To: Paul Brown
Felsburg Holt & Ullevig

From: Max Rusch, P.E.
Galloway

Re: **Comment Response to 3/2/2023 Comments**

This memorandum serves as a comment response to the comments provided by the FHU and El Paso County on 3/2/2023 in response to the "Owl Place Storage Traffic Impact Study", submitted on 1/25/2023. The received comments and the accompanying responses are located below.

R1.0
Sheet 1 of 1

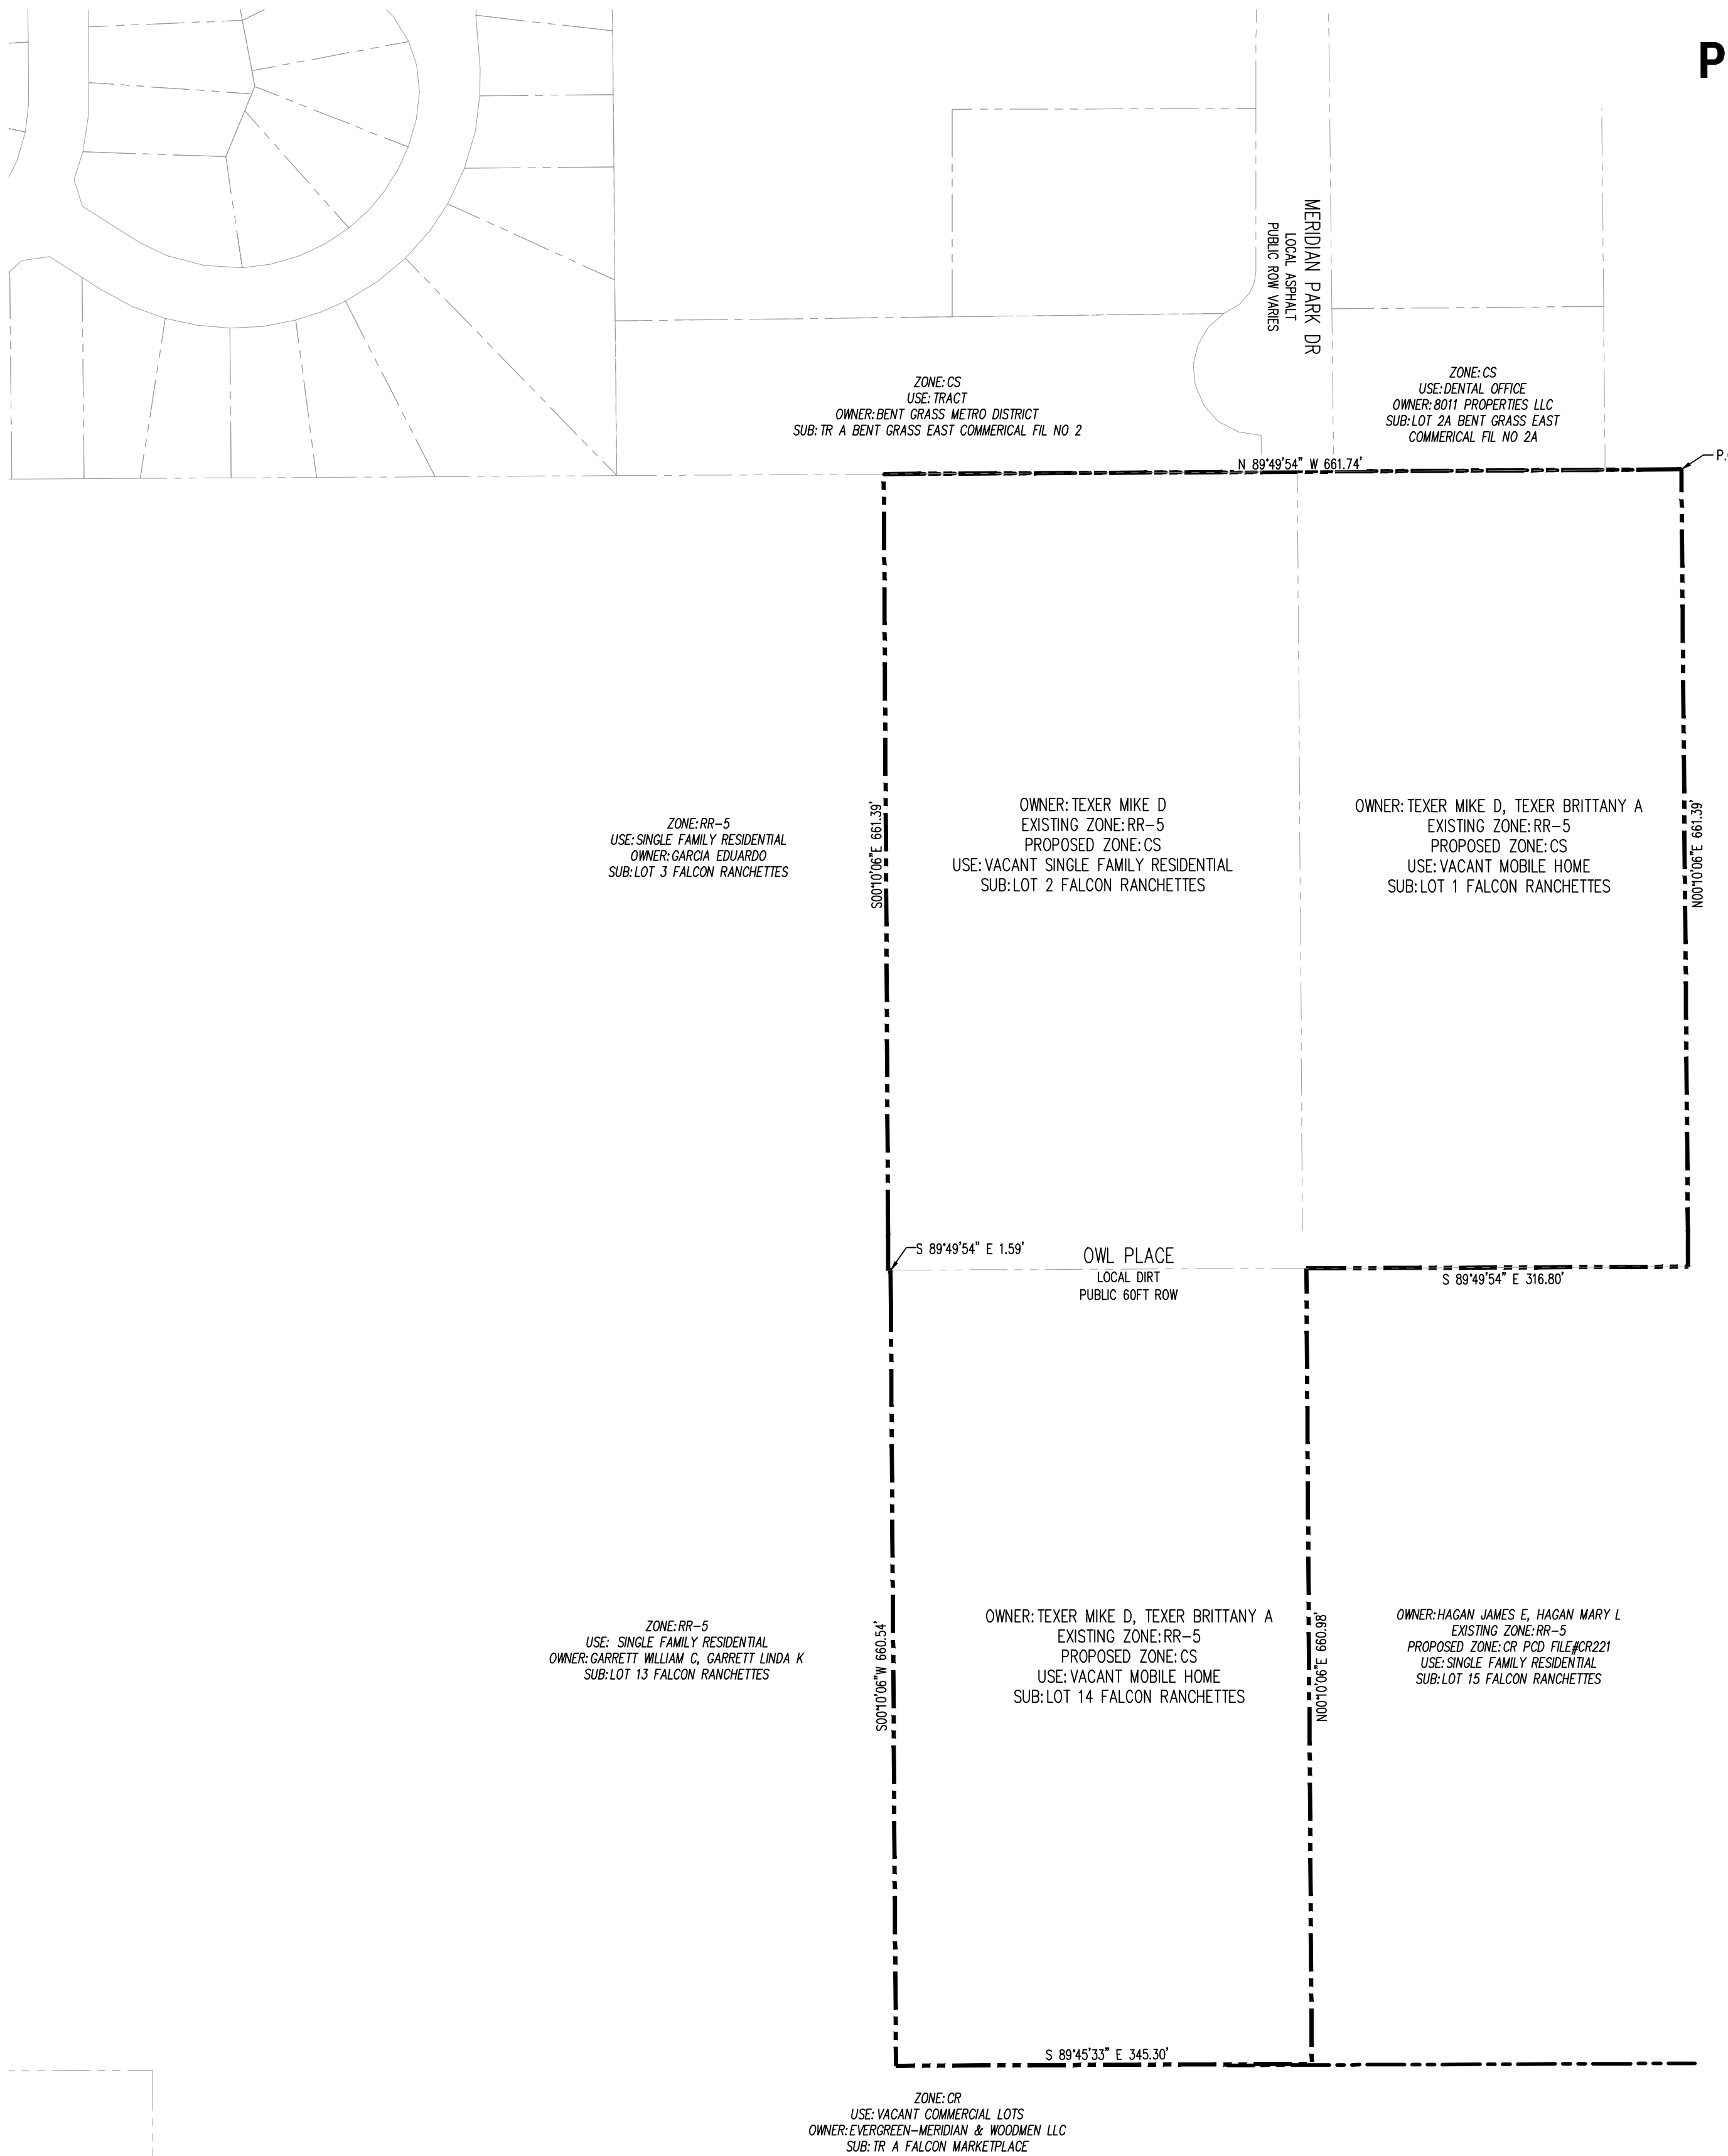
Please correct map to match zoning map. Missing parcel areas

Site Plan missing parcel area

Response: The zoning map has been updated to show all three parcels.

Response: The missing parcel has been included in the revised site plan.
